Application by Roxhill (Junction 15) Limited for a Development Consent Order for the Northampton Gateway Rail Freight Interchange

The Examining Authority's written questions and requests for information (ExQ2)

Issued on 5 February 2019

Figure 9.4: A508 Corridor Construction Phase Receptors

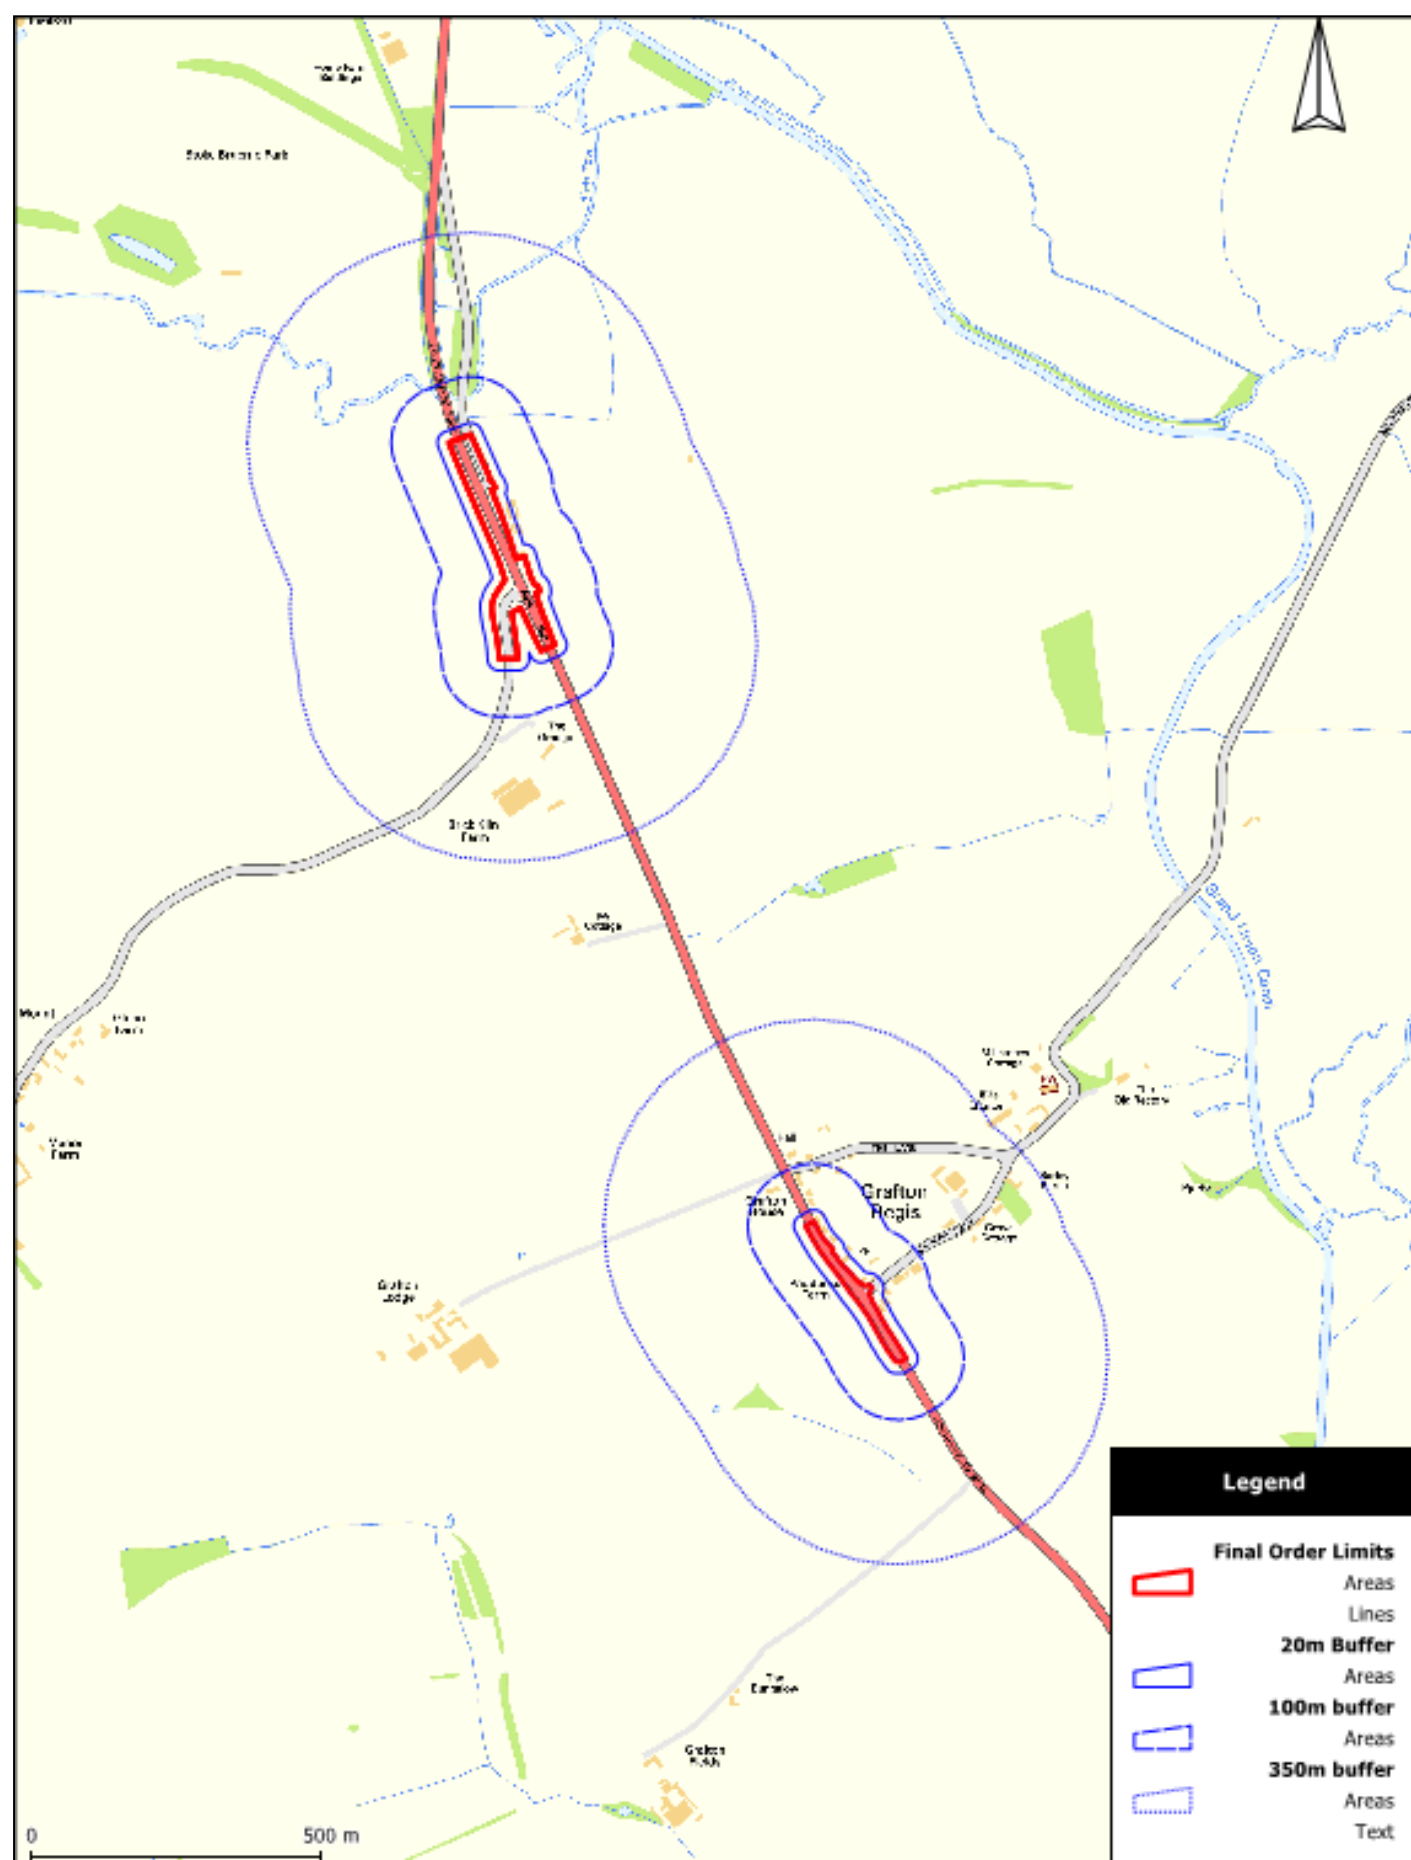
2.1.19.		<p>Para 9.6.3 on Dust Mitigation says "The highest risk activities will be avoided in the areas of the Main Site closest to sensitive receptors. These are shown as a Priority Dust Mitigation Zone on Figures 9.1, 9.2, 9.3 and 9.4. However, there do not appear to be any such zones on those Figures and they are referred to only in the Legend of Figs 9.1 and 9.2. Please will the Applicant explain where they are described in the text so that the ExA can understand where they are and provide updated figures to show these</p>

ExQ2	Question to:	Question:
		<p>zones?</p> <p>Please can the Applicant also explain how this mitigation is secured? The Priority Dust Mitigation Zones do not appear to be mentioned in the Commitments Tracker (Doc 6.11A [REP3-003]).</p>
